# CITY OF ALBUQUERQUE

April 18, 2022

**Re: Pima Medical Institute New Class Room Building**  
**4400 Culter Ave NE**  
**Traffic Circulation Layout**  
Architect's Stamp NO date provided (H17-D054B)

TCL001

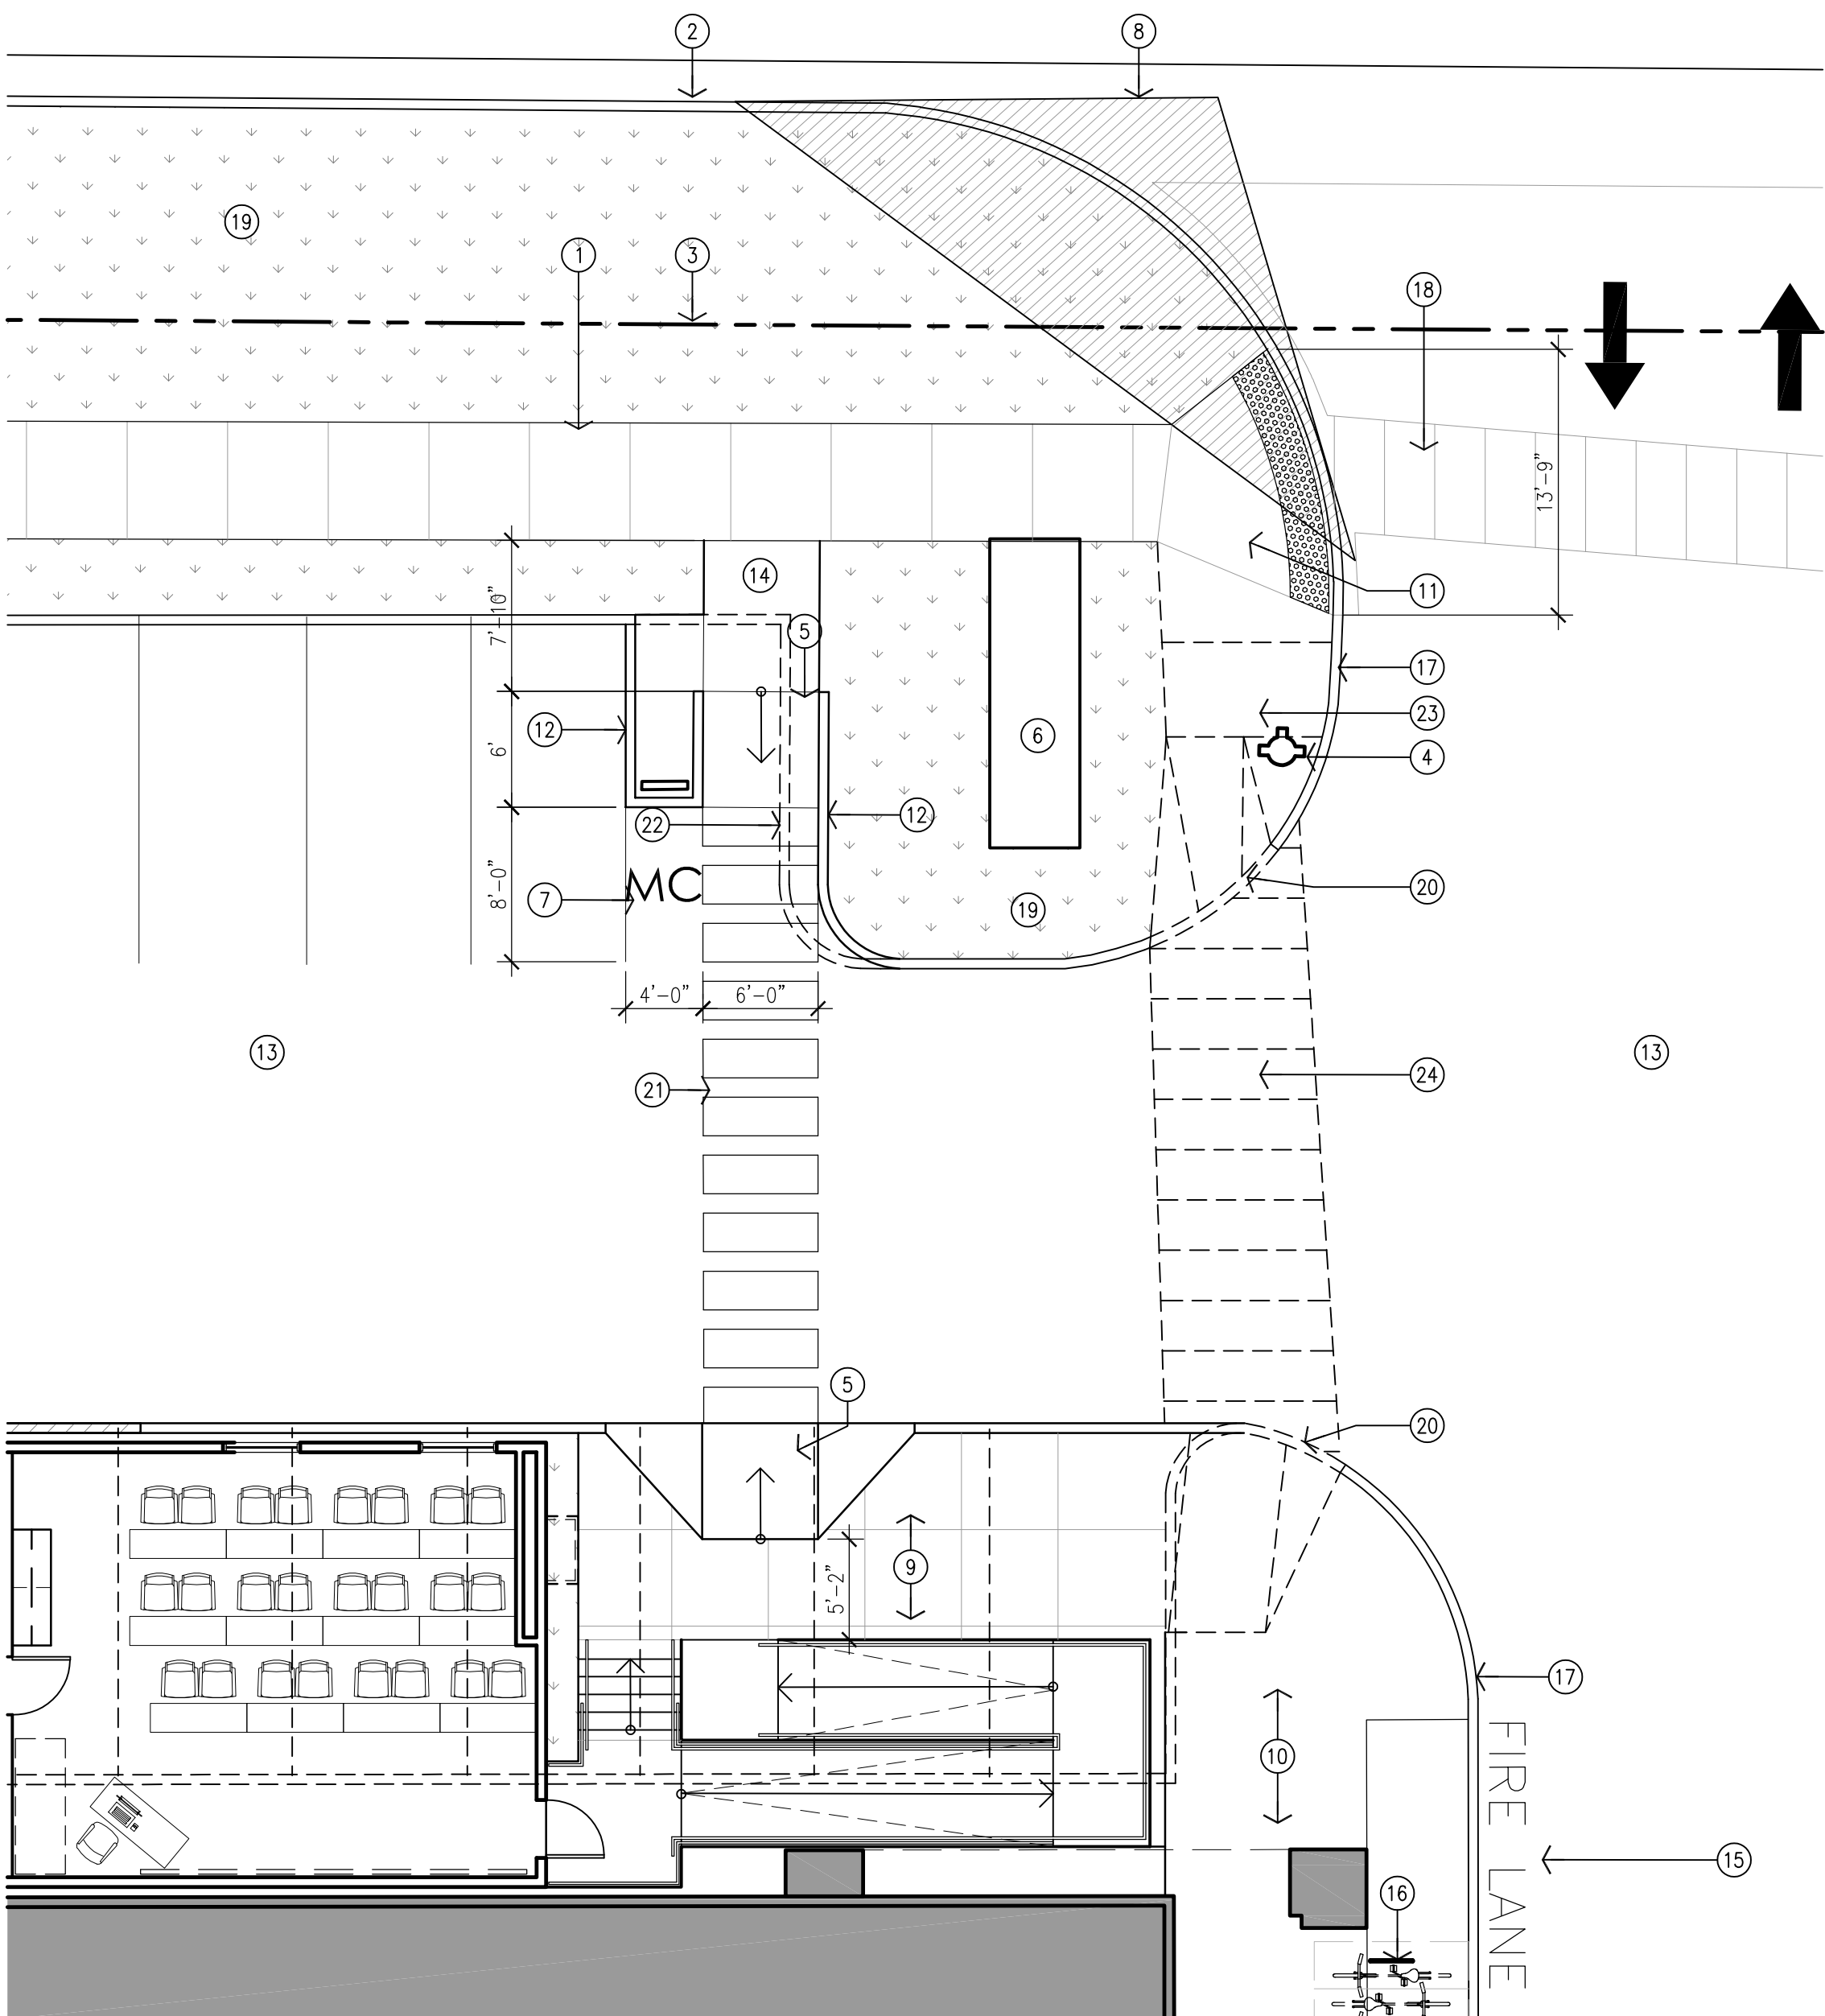
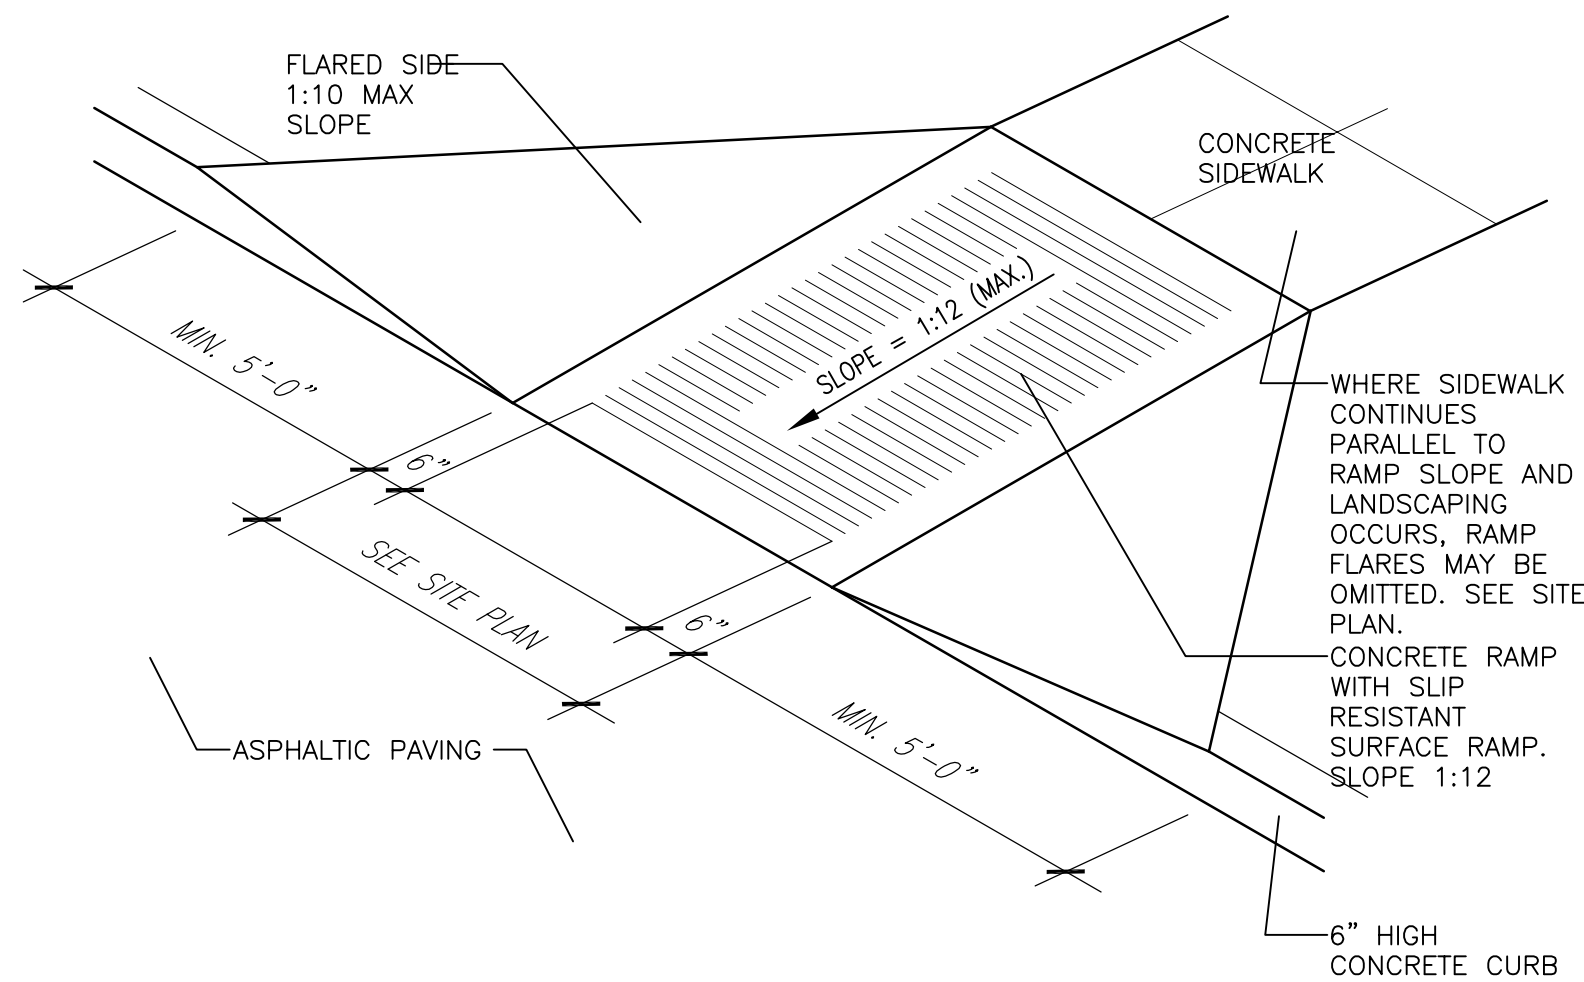
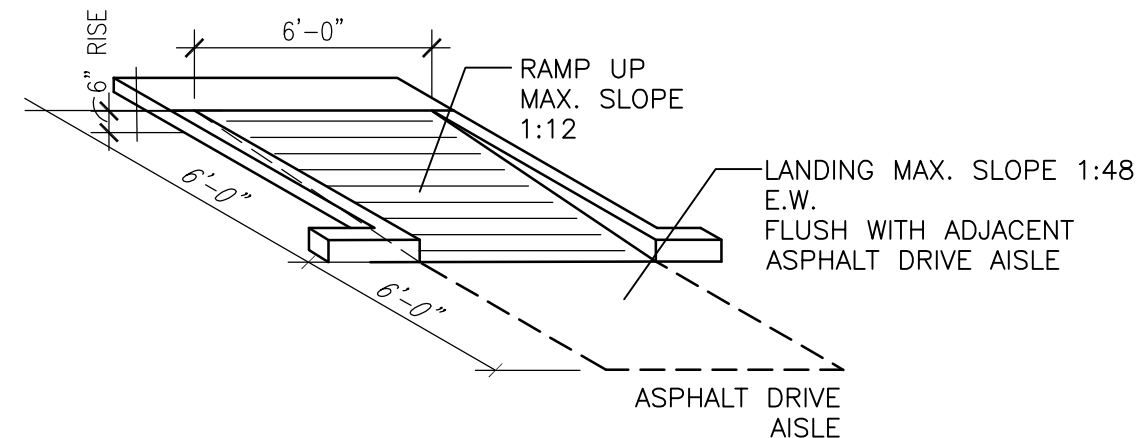
- The current ramp run (12:10) connection onto the sidewalk connection is not ADA accessible.
  - Per the DPM, a 6 ft. wide ADA accessible pedestrian pathway is required from the public sidewalk to the building entrances. Please clearly show this pathway and provide details and demo any existing/old sidewalk connection that doesn't meet the requirements above. Make sure you provide striping for this 6ft pathway across the drive aisle.

- **You will need a Sidewalk Easement for existing sidewalk located outside of public ROW. See attachment for the forms.**
3. **Handrail detail:**
  - Dimension all pathway widths on the proposed run/tapers and landings (including bottom, middle and top). Label all landings 48:1 **MAX** and all runs/tapers 12:1 **MAX**.
